CITY OF PORTLAND, MAINE

PLANNING BOARD

June 2nd, 2014

Project Name: **Six Unit Commercial Building**
Project ID: 2014-016 CBL: 296-A006001
Address: 421 Warren Avenue, Portland
Joint Applicants: PH Warren Avenue, LLC
Planner: Jean Fraser

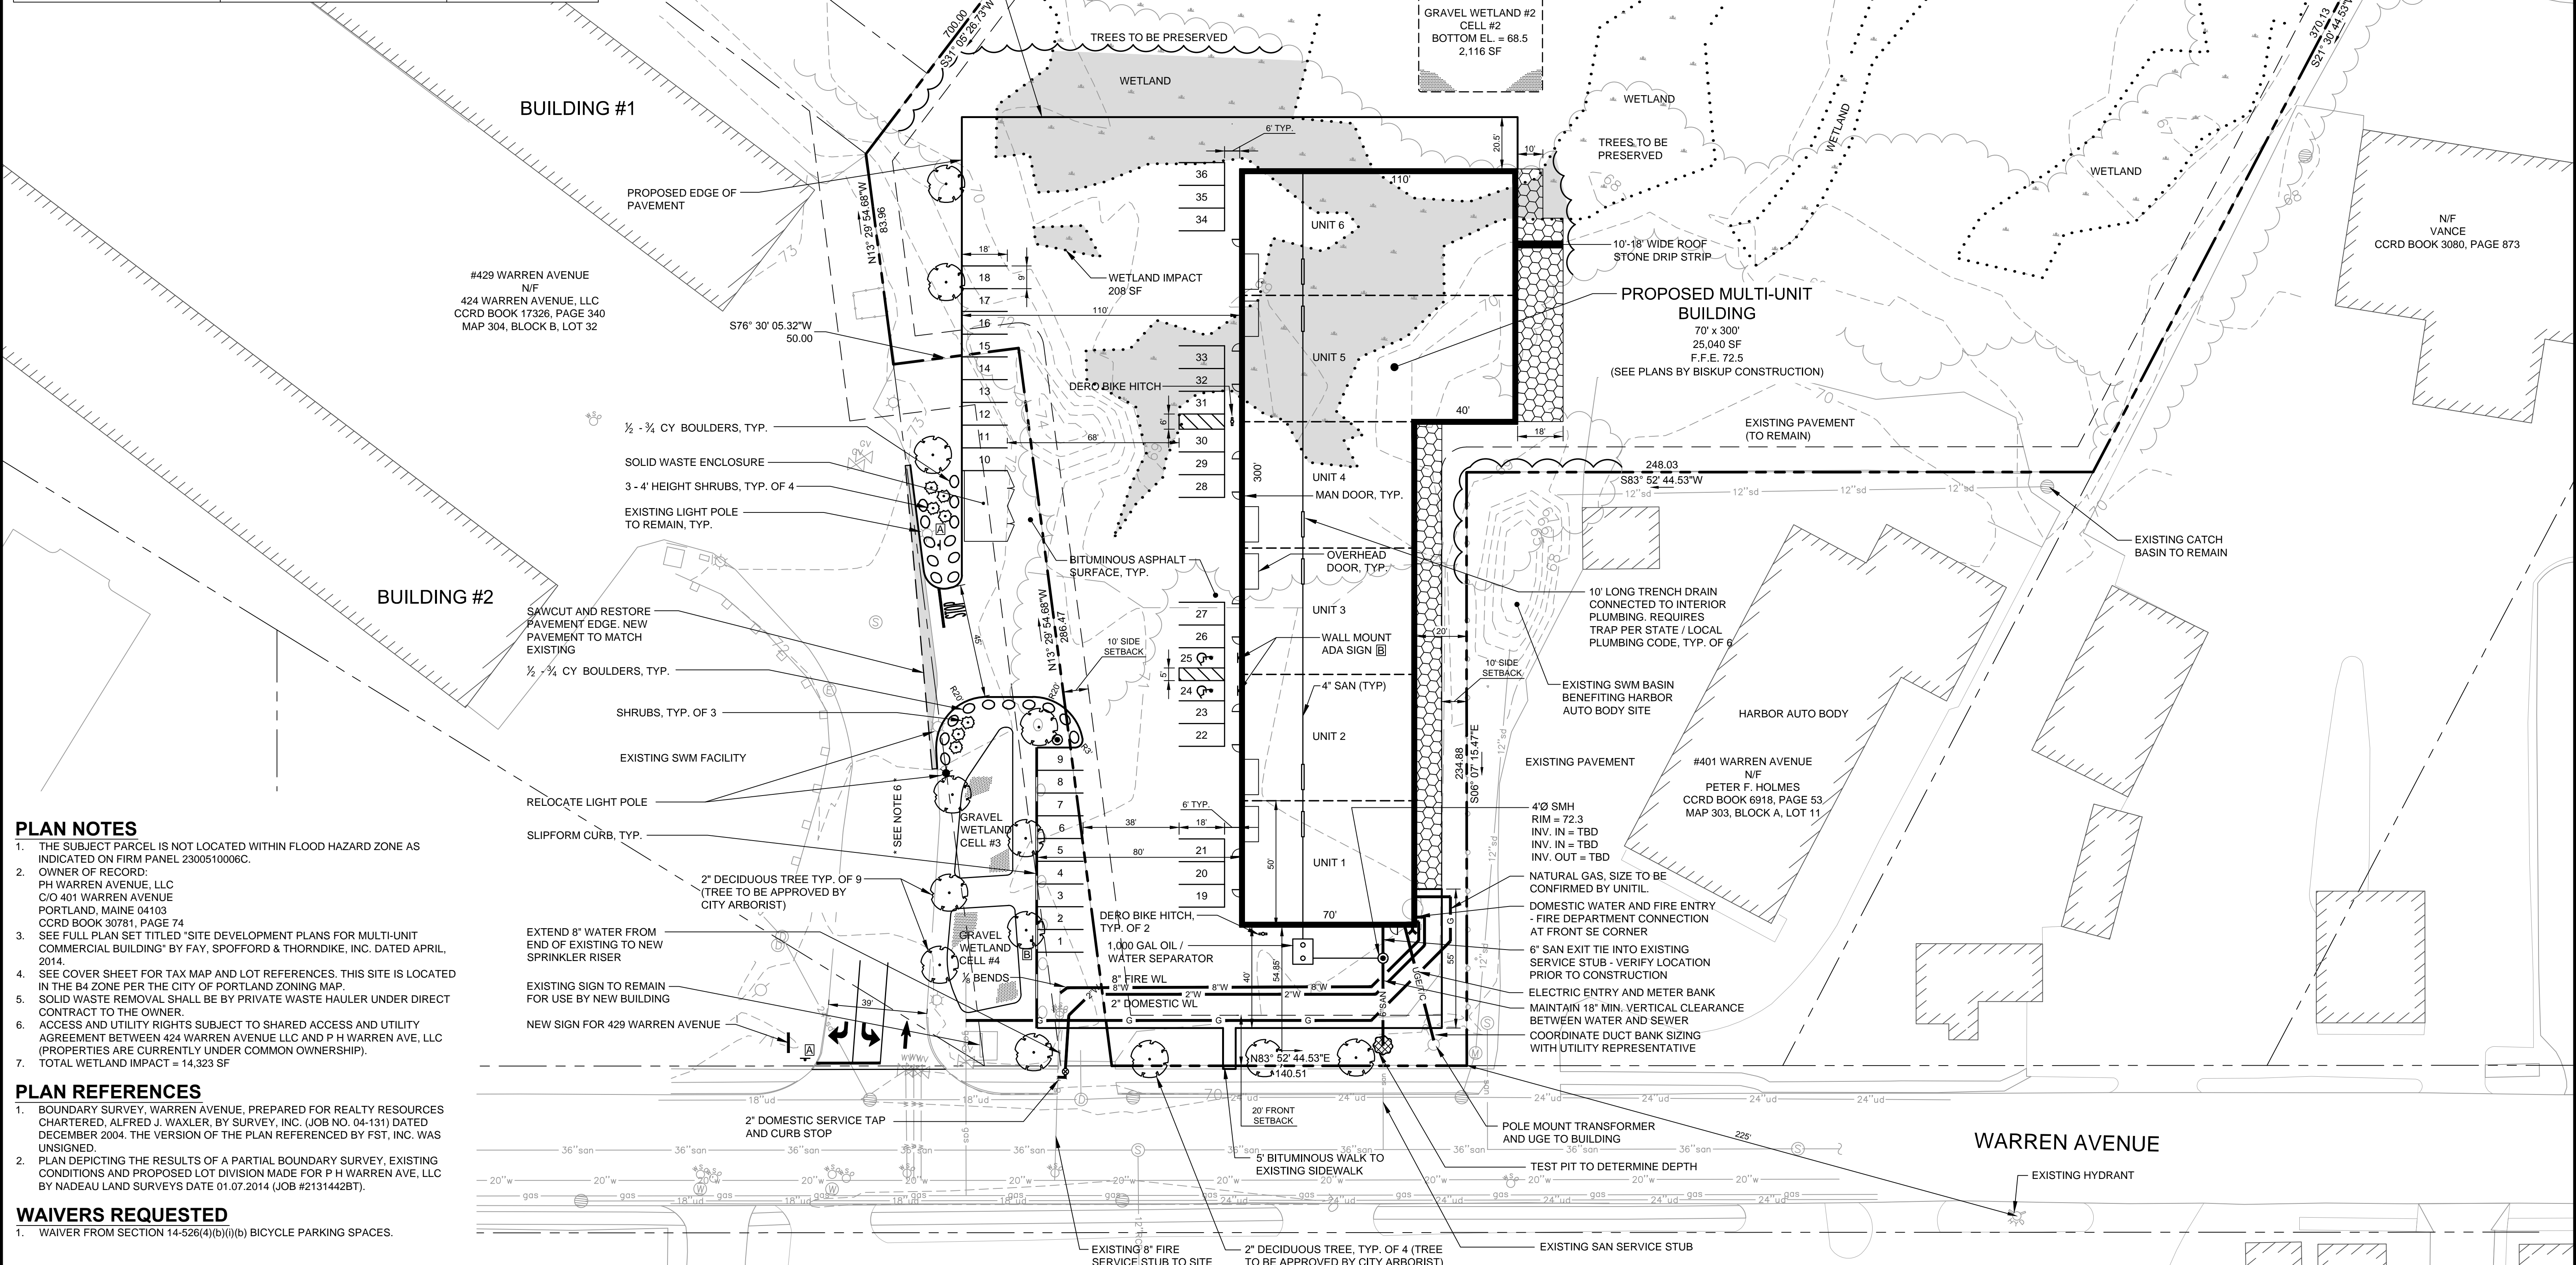
- ii. That the applicant shall submit a Landscape Plan, based on an a submitted assessment of the trees on the site, that shows the following: tree saves; any required replacement planting; and additional planting; snow storage areas; all to address the landscape preservation and parking lot landscaping requirements of the Site Plan Ordinance (14-526), for review and approval by the Planning Authority and City Arborist; and

- vii. That the applicant shall close the existing curb cut on Warren Avenue (east of the joint access from Warren Avenue into the site); install three signs along the back of the property where the asphalt ends stating: DO NOT DUMP - IMPAIRED WETLANDS; and shall mark with paint the pedestrian walking area in front of the building and between the building and Warren Avenue sidewalk; all prior to the issuance of a Certificate of Occupancy; and
